**Surrey Heath Borough Council Deadline 7 Submission**

**Written Response to the The Examining Authority's written questions and requests for information (ExQ2) and submissions by Esso Petroleum Company Limited**

**Esso Petroleum Company Limited Southampton to London Pipeline Project Application for a Development Consent Order**

**Project reference no. EN070005**

- TREE TO BE REMOVED

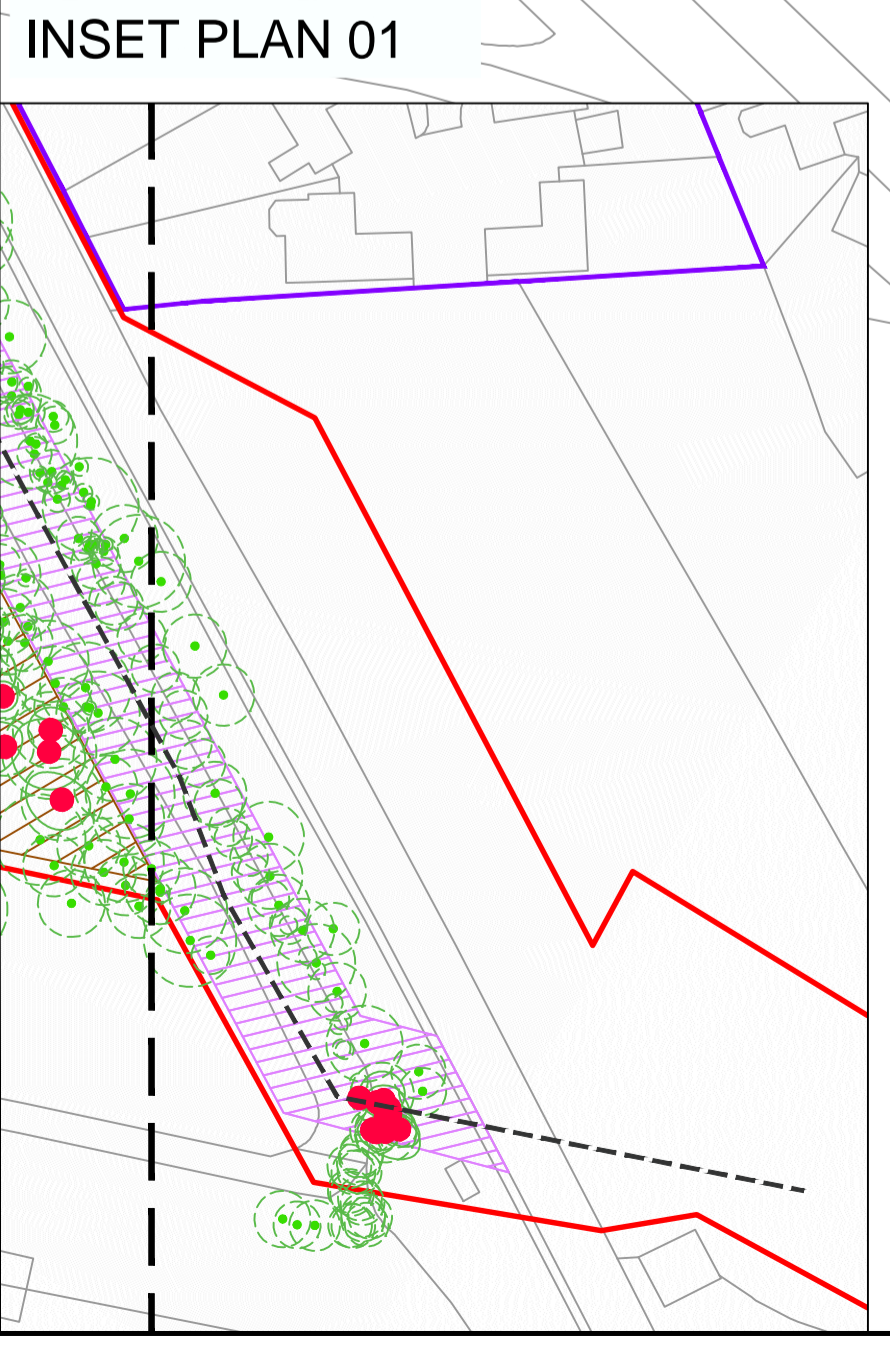
With regard to paragraph 3.2.2 the proposed site compound is shown to be located in a relatively high density area of trees consisting of roughly 50/50 Silver Birch of a mainly early to mature age class, and Scots Pine of a more mature bias. The suggested number of trees to be removed for the access route of 18 self-set Silver birch is considered to be an underestimate and realistically double would be as more

accurate assessment. The compound removal estimate of 21 trees, but none of a mature status, is again considered to be unrealistic and there are at least 10 mature trees with another 25/30 early mature to be removed. Consideration should be given to other options which would require a significantly lower number of less important trees to be removed.

The 'footpath' to which the pipeline is to be located is approximately 6m wide. The information in the applicant's report details a working area of 10 /15m wide and the actual trench a width of 1m and unknown depth. This working area does then include a significantly greater number of trees than shown on their BS5837:2012 drawing and additionally when looking at the intended pipeline location there is a greater impact on supposedly retained trees.

Along the whole pipeline length the intended method of excavation is an 'open cut trench. This will undoubtedly result in unacceptable amounts of root damage and of a root diameter exceeding the B.S. criteria, especially when their RPA calculations from some of the more critical trees do not appear to be correctly represented. Whilst noting the provision at paragraph 3.5.2, which should include reference to an appropriately qualified arboriculturalist, the Council has concerns that this would result in further tree loss to that identified, particularly given ground level variations and other root growth restrictions.

It is considered that, having regard to trees above a stem diameter of 200mm which will be necessary to remove to achieve the pipeline installation, there are in addition to the applicant's assessment of 21 trees, another 30 to be removed. These are of a proximity that even with a none mechanical excavation method, are of such close proximity that roots over 100mm in diameter will be revealed and how these could be retained whilst trying to lay this large pipe would be challenging if not viable. Unless the whole process is carried out under full arboricultural supervision then it is considered that roots would be severed on a frequent basis.
